19 May 2021

**Response to Notification of Request for SEAR's: Snack Brands  
Manufacturing Facility SSD-18204994 – 14 Distribution Drive, Orchard Hills**

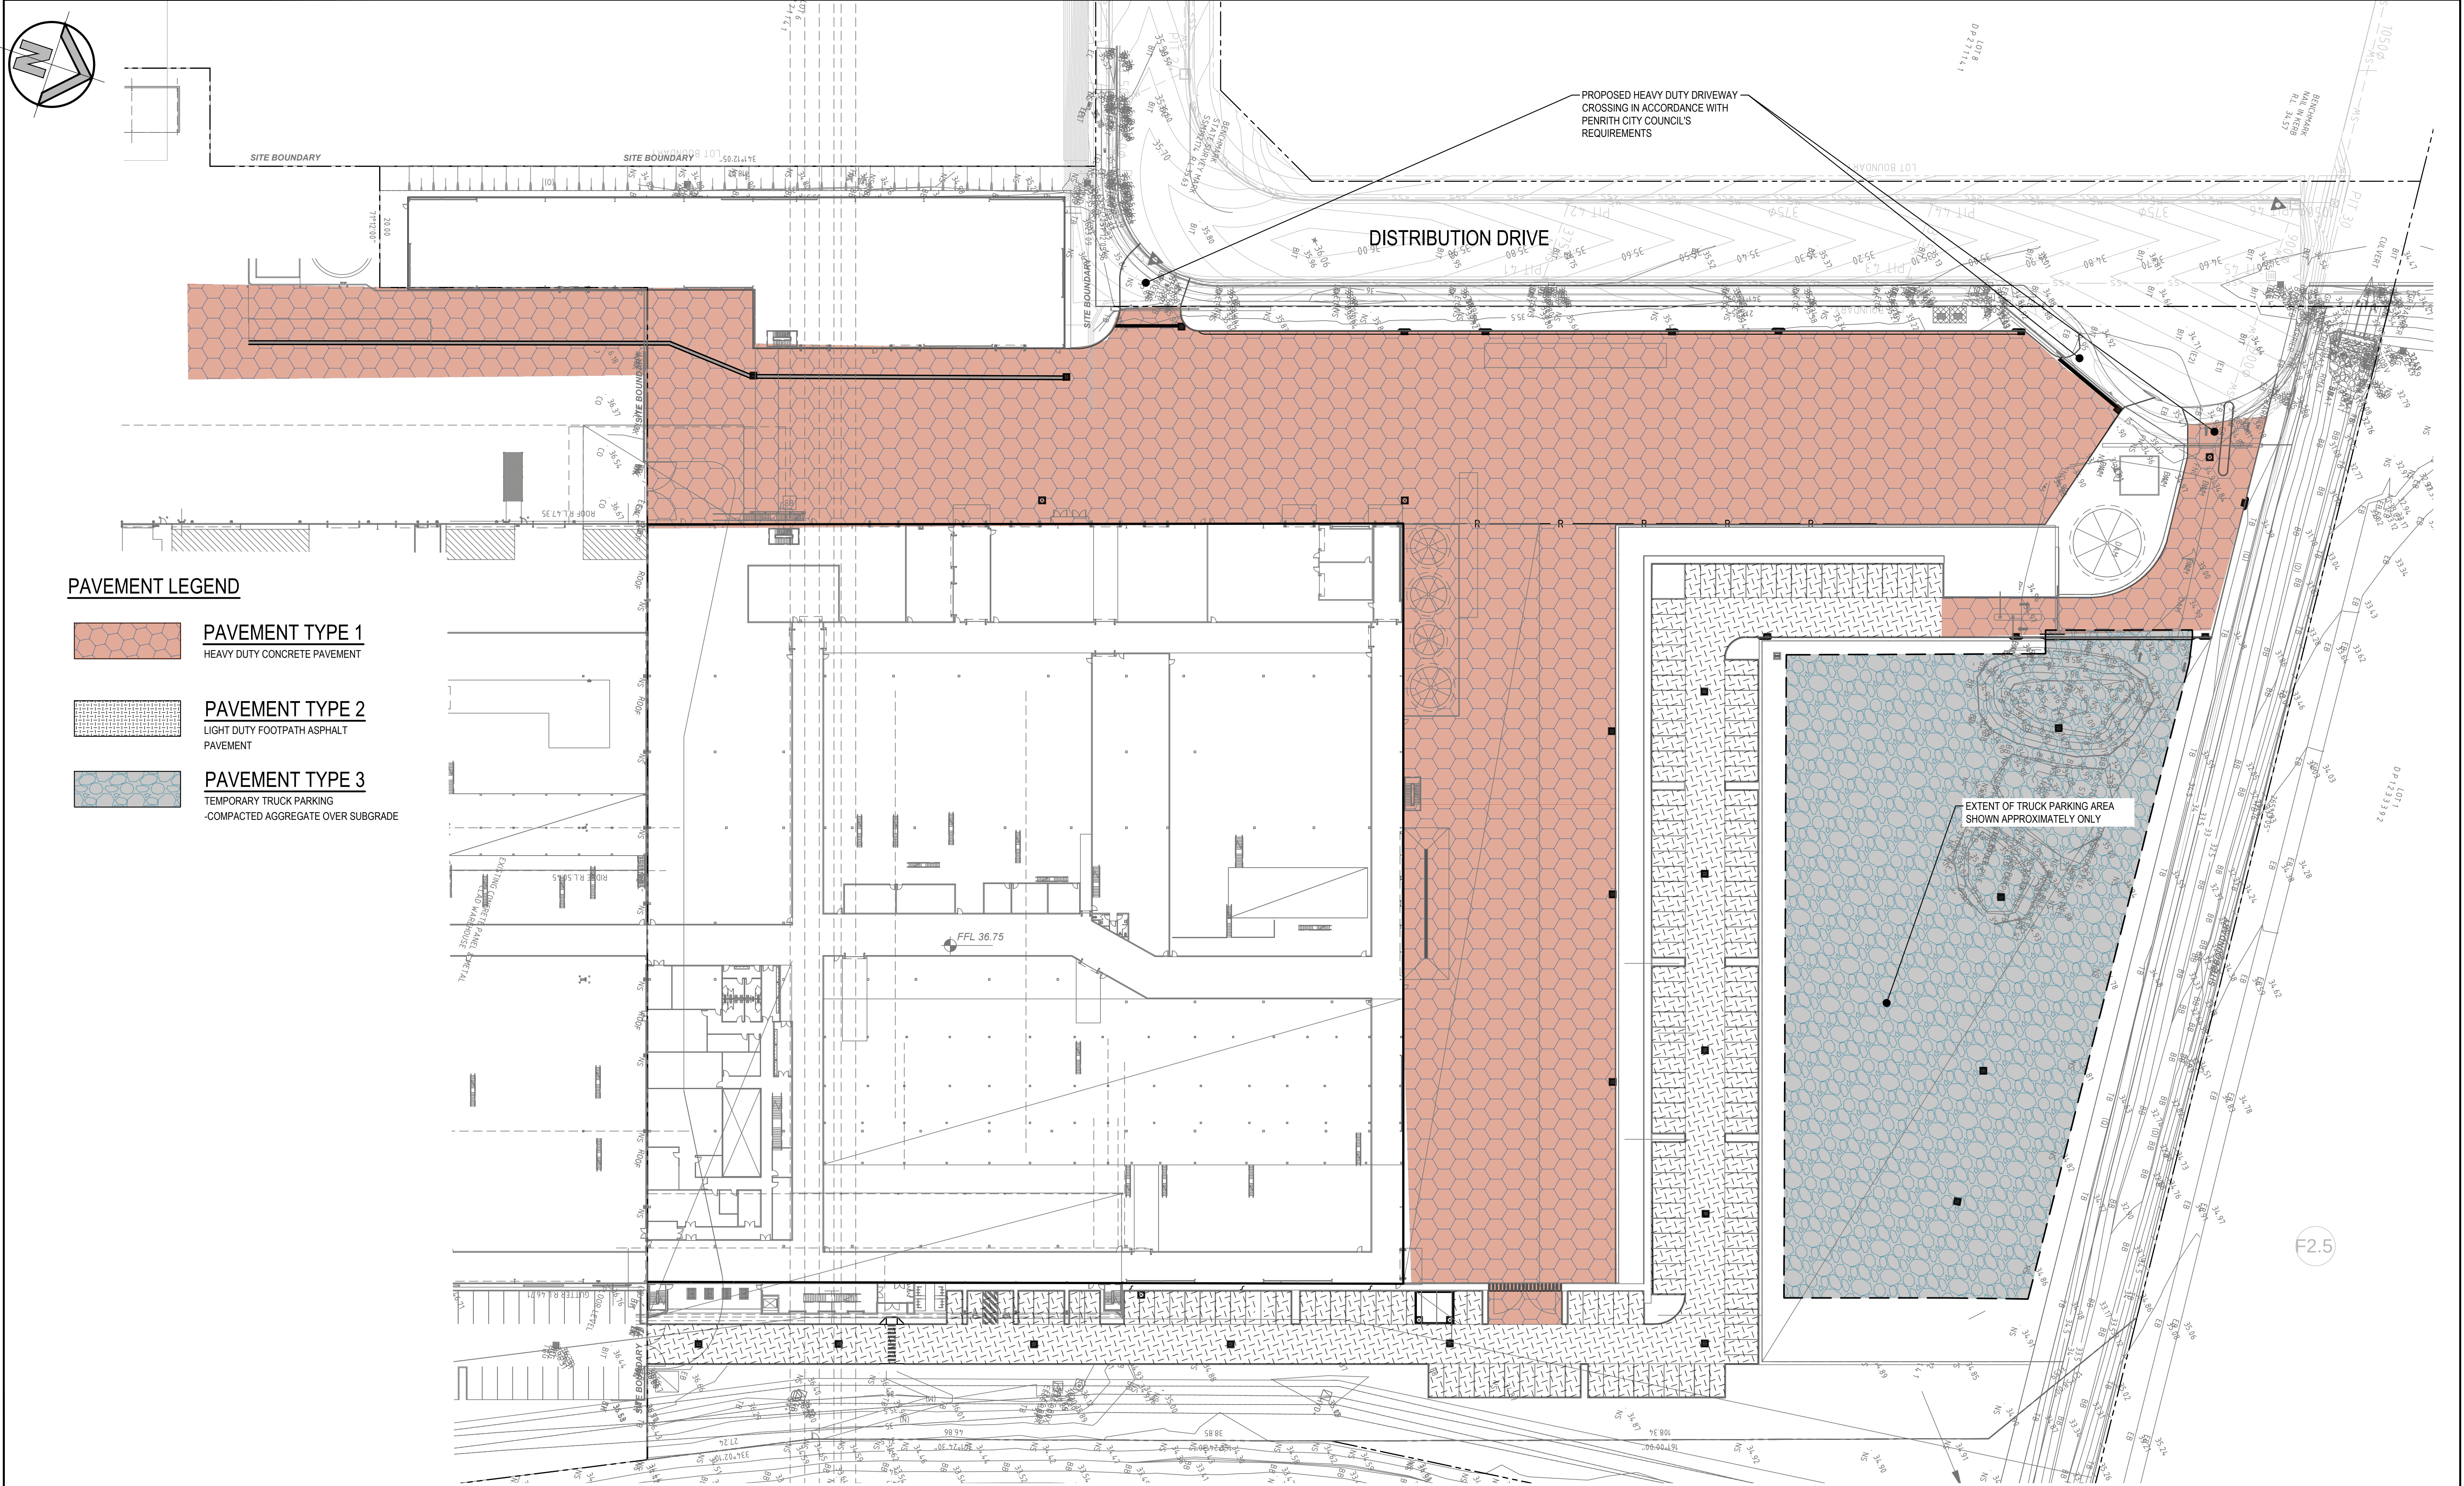
Rainwater harvesting should / would also be applied across the site (where considered practical), which will incorporate re-use in irrigation methods and recycled potable water components, i.e. toilet flushing.

All proposed WSUD systems must be accompanied by an electronic MUSIC model in sqz format to confirm compliance with councils WSUD policy.

SEDIMENT AND EROSION CONTROL PLAN
SCALE: 1:500

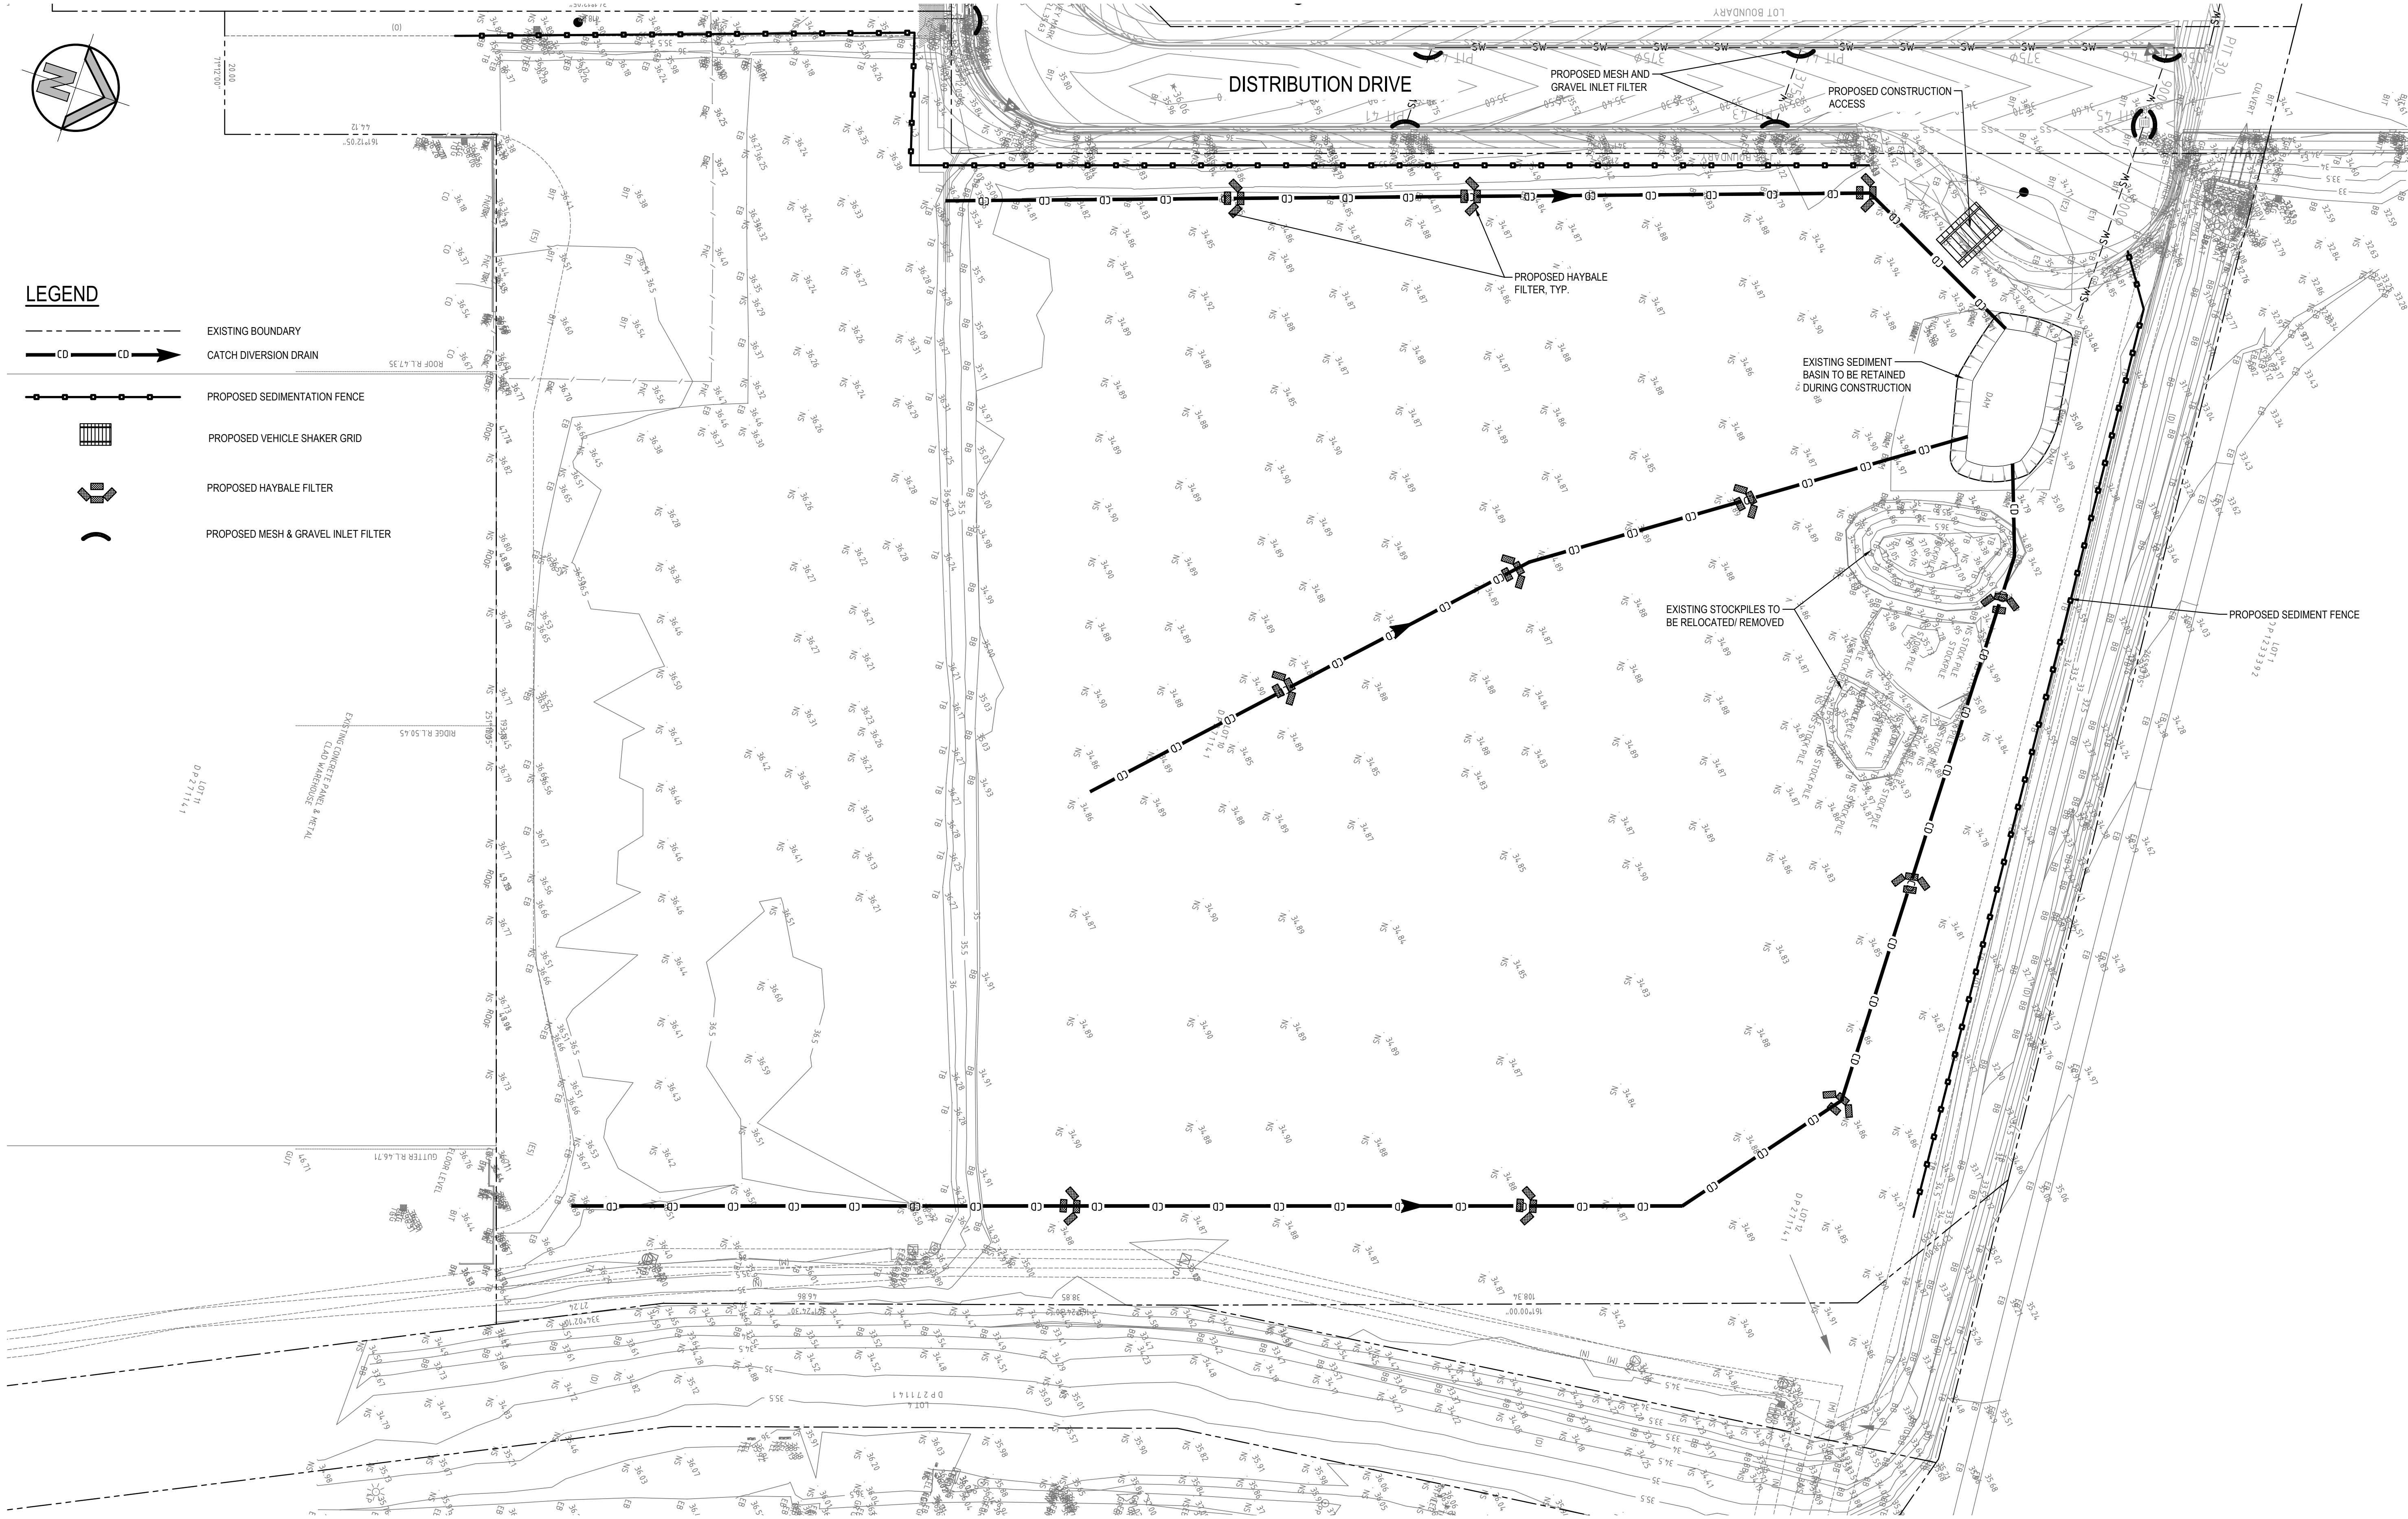
The applicant should provide a detailed Erosion & Sediment Control Plan to Council prior to the determination of this application that conforms to Council's Development Control Plan including, but not limited to:

- Location of stockpiles during construction;
- Location & details of all-weather access;
- Location & details of erosion and sediment control measures – sediment fences, vegetation strips etc;
- Location & details of stormwater pit protection measures (internal & external); and
- Location of waste storage area during construction.
